Application for Planning Permission for Works or Extension to a Dwelling

Development: Two storey side and single storey rear extension.
Location: 8 Lloyd Goring Close Angmering BN16 4LQ

PROPOSED BLOCK PLAN 1:200  
0 1 2 3 4 5 6 7 8 9 10 11 12 13 14 15 16

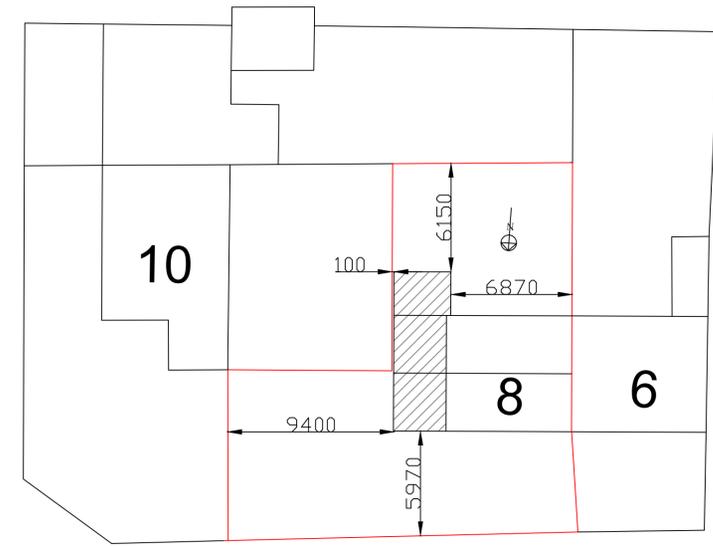
Block Plan

You are required to have dimensions from the proposed extension(s) to all site boundaries. Please amend.
